# CITY OF ALBUQUERQUE

September 1, 2023

**Re: G.A.A.R Office Building  
1635 University Blvd. NE  
30-Day Temporary Certificate of Occupancy  
Transportation Development Final Inspection**  
Architect's Stamp dated 05-20-22 (H15-D008)  
Certification dated 08-15-23

A1 TRAFFIC PLAN
1" = 40'-0"

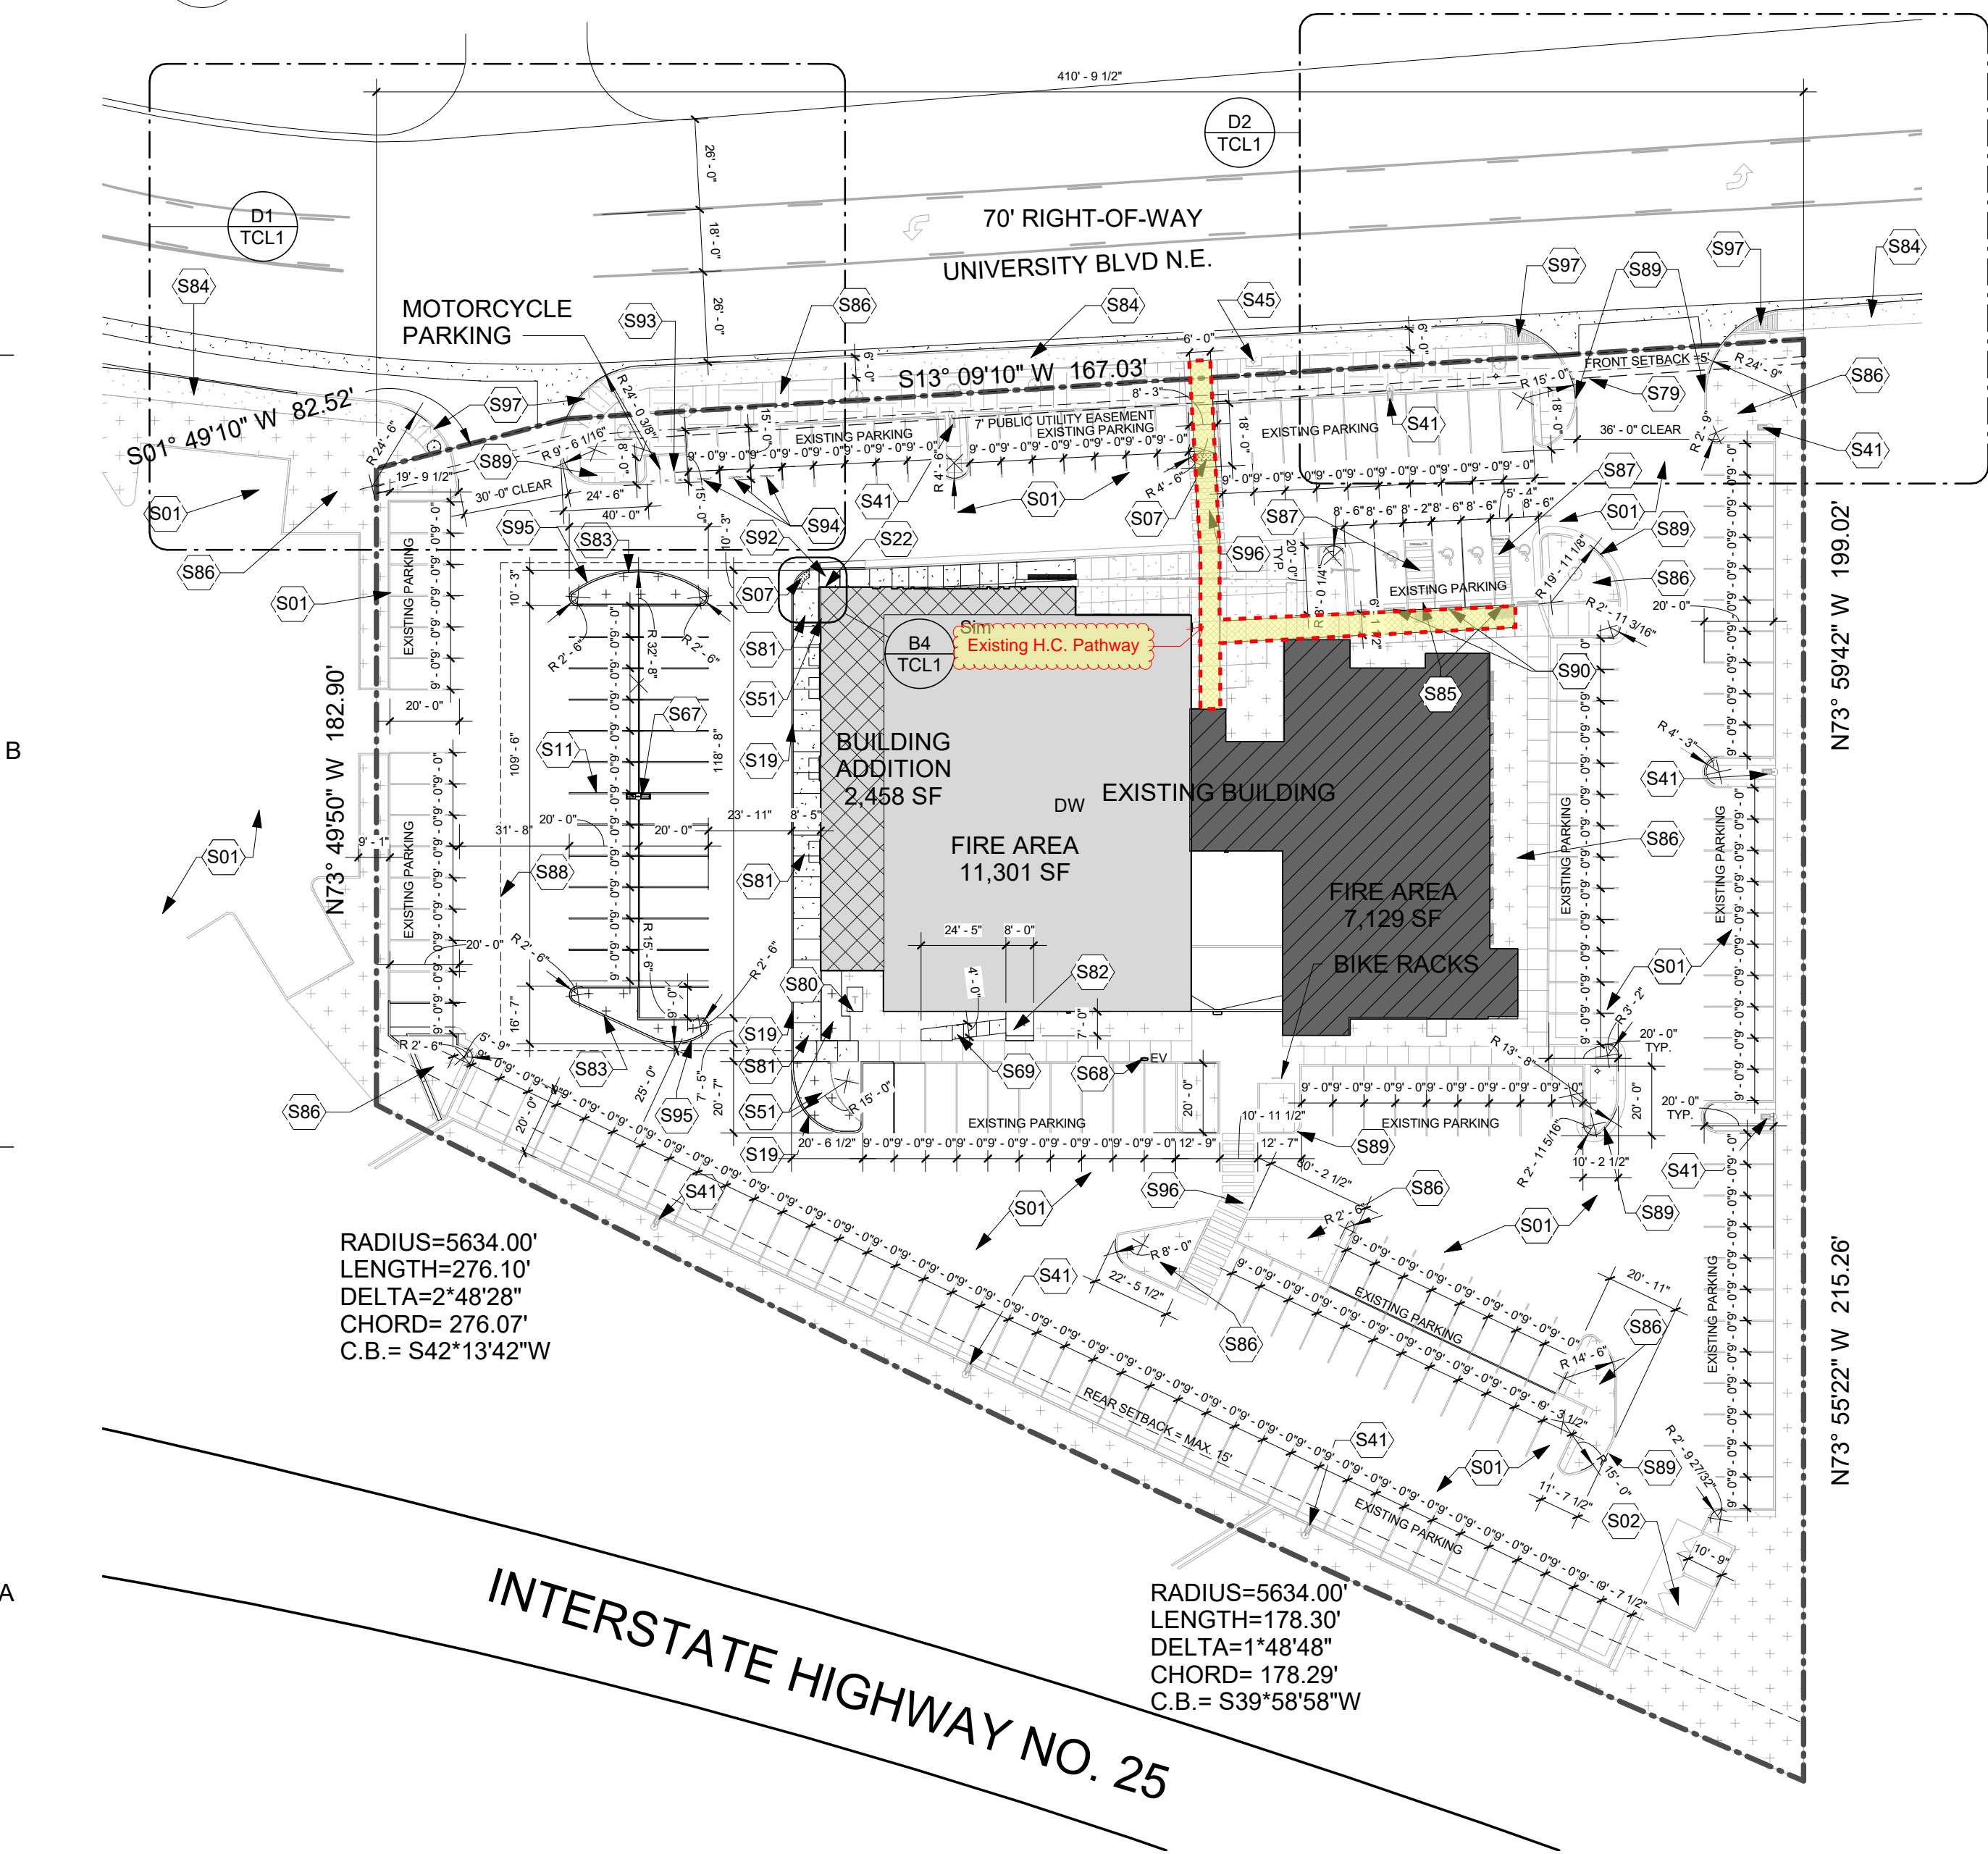
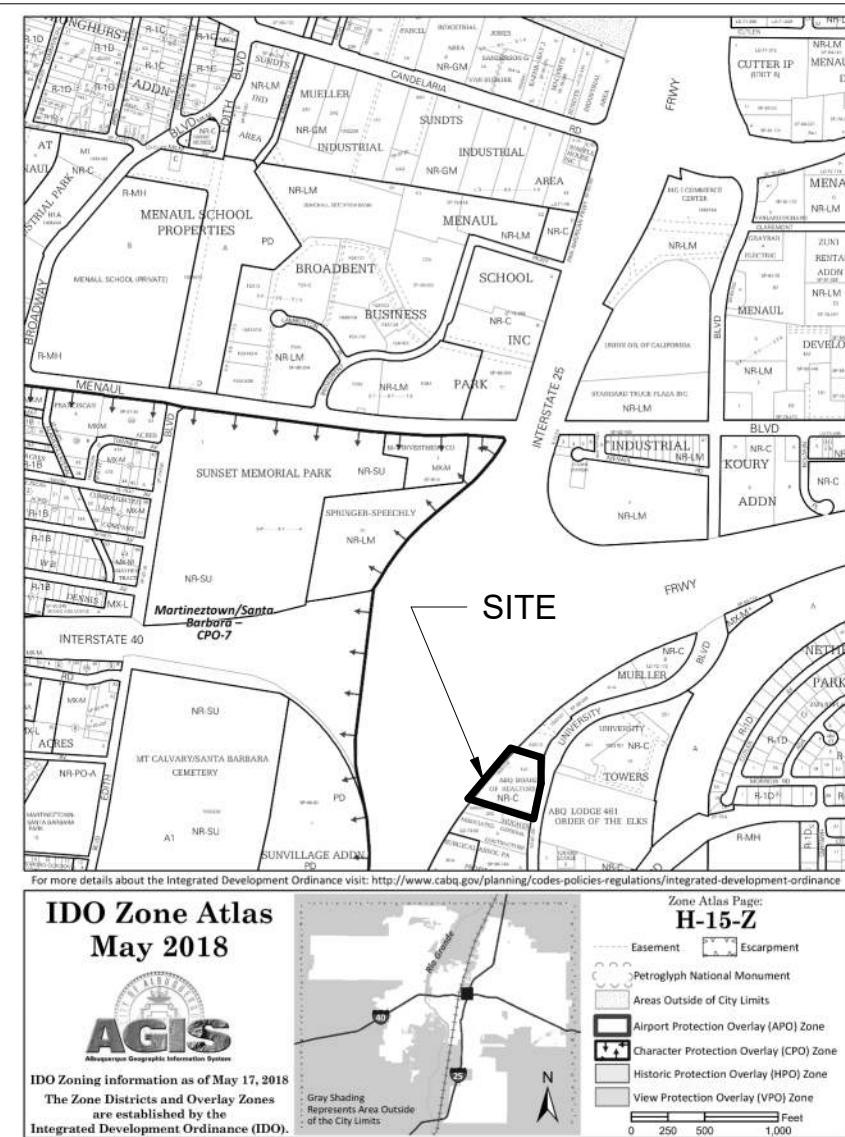
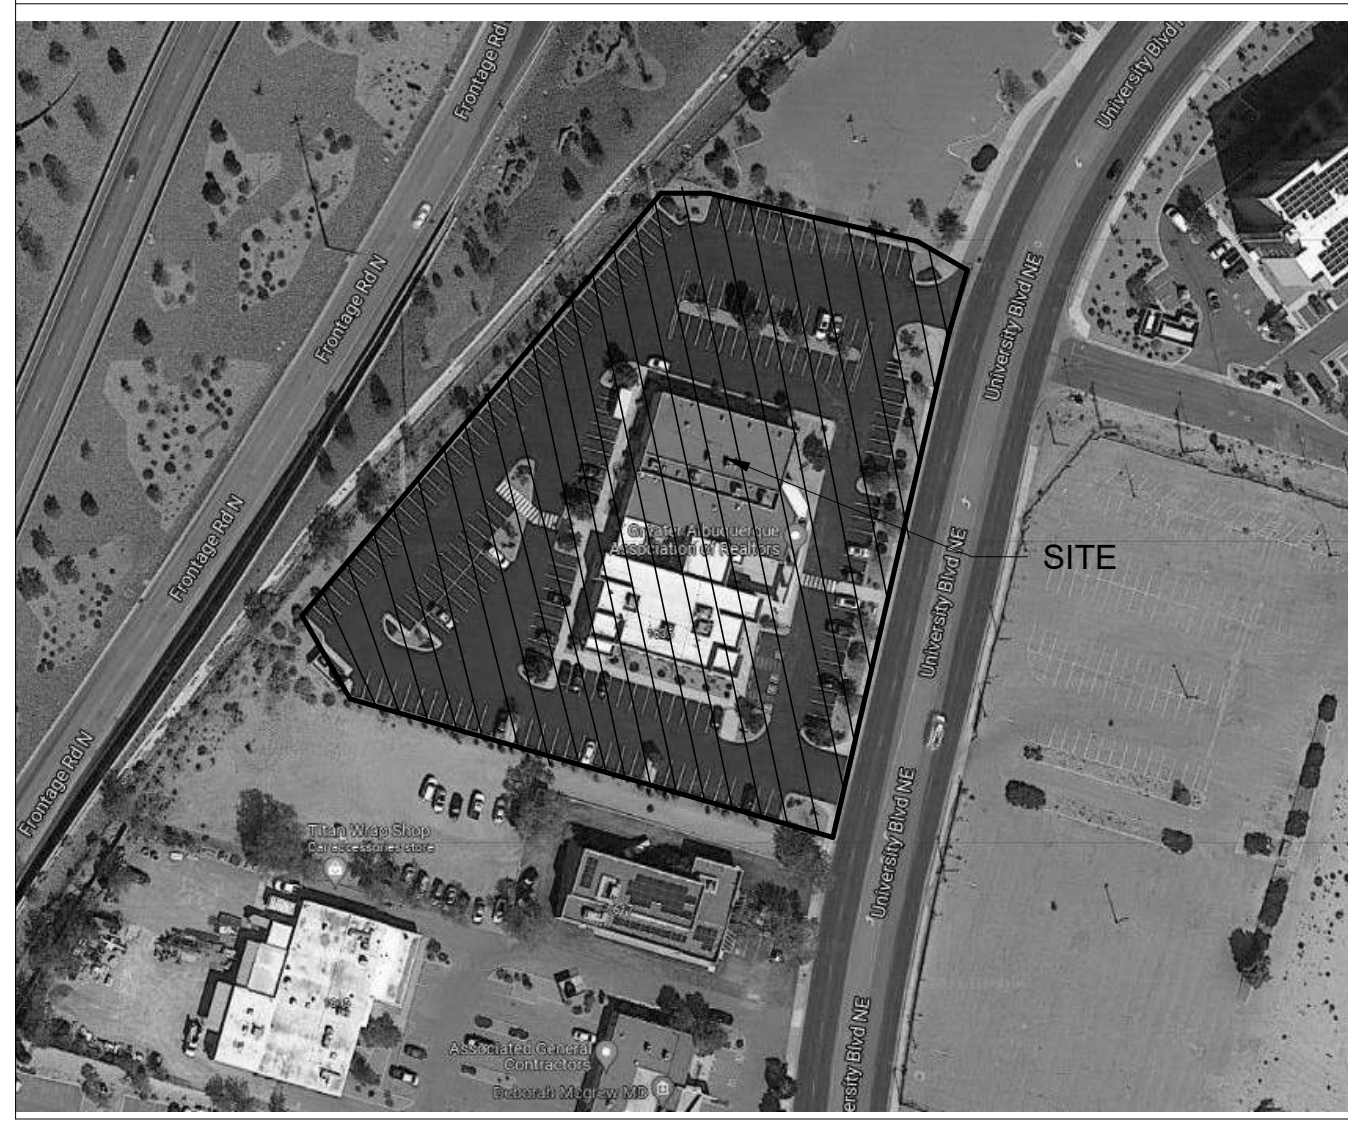
- Per the approved site plan, ADA parking space width is 8.6'. per site visit the ADA parking space width was 8'. Please provide a minimum of 8.5' wide ADA parking spaces.
- Truncated Domes must be installed at the existing ADA ramps for both site accesses.

- Tripping hazard key note S07: please provide a smooth transition between the new ADA ramp and the drive surface.

- Please stripe (repaint) the north side parking spaces.
